Sydney Metro West - Concept and Stage 1 - Modification 2 (SSI-10038 MOD 2)  
**Request for additional information**

I refer to the Sydney Metro West - Concept and Stage 1 (major civil construction between Westmead and The Bays) Modification 2 (SSI-10038 MOD 2). The Department requires additional information in regard to the proposed realignment of Kay and Unwin streets at the approved Clyde Maintenance and Stabling Facility and its consistency with strategic planning for the area, including draft strategic plans.

Figure 4-2 Kay Street and Unwin Street route realignment (proposed modification)

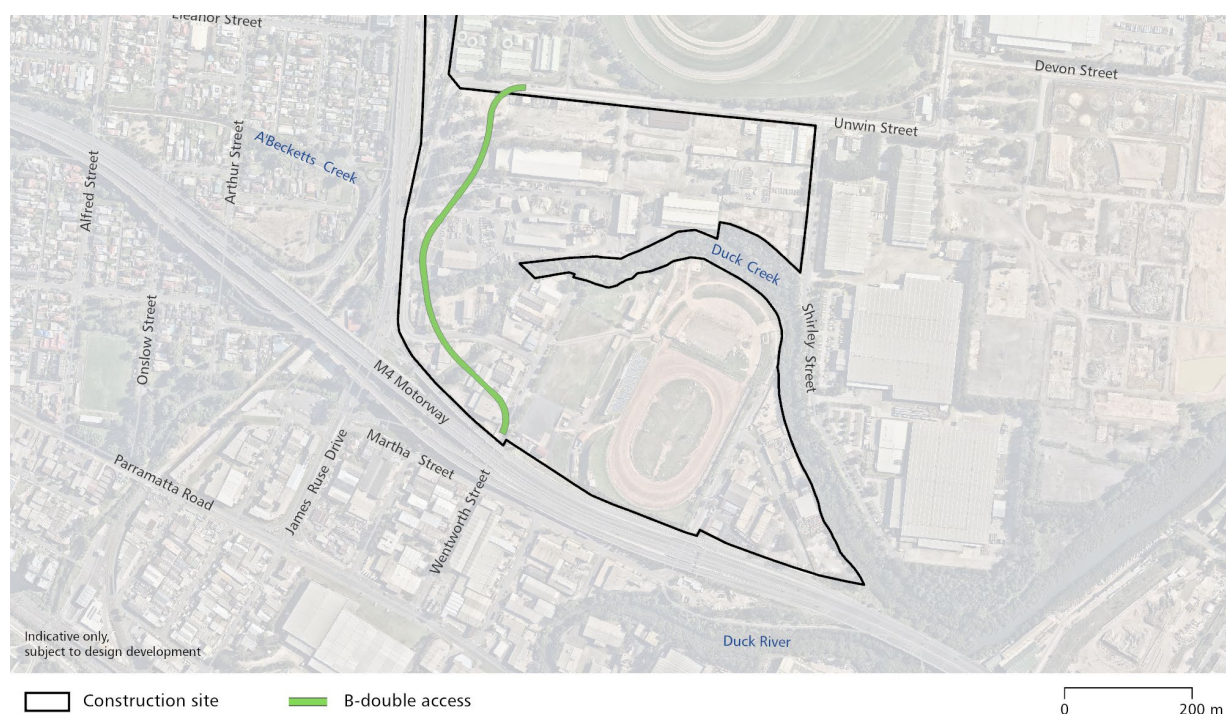
- how the proposed realignment of Kay and Unwin St is compatible with potential connections, specifically the identified connection between Kay/Unwin Street and the M4 Motorway identified in the *Draft Camellia-Rosehill Place Strategy* (2021), the *Greater Parramatta Interim Land Use and Infrastructure Implementation Plan* (2017), and the *Western Sydney Regional Ring Road Strategy* (2012)
- current designs, drawings, and modelling for the proposed Kay/Unwin Street realignment, including CAD drawings and flood modellings to confirm that a potential M4 connection can be delivered in the next 5 to 10 years, as identified in the *Draft Camellia-Rosehill Place Strategy*.

While the Department acknowledges that a potential connection between Kay/Unwin Street and the M4 Motorway is beyond the scope of Sydney Metro West, the assessment of the proposed modification should consider the ability for infrastructure identified in strategic plans to be delivered in the future.
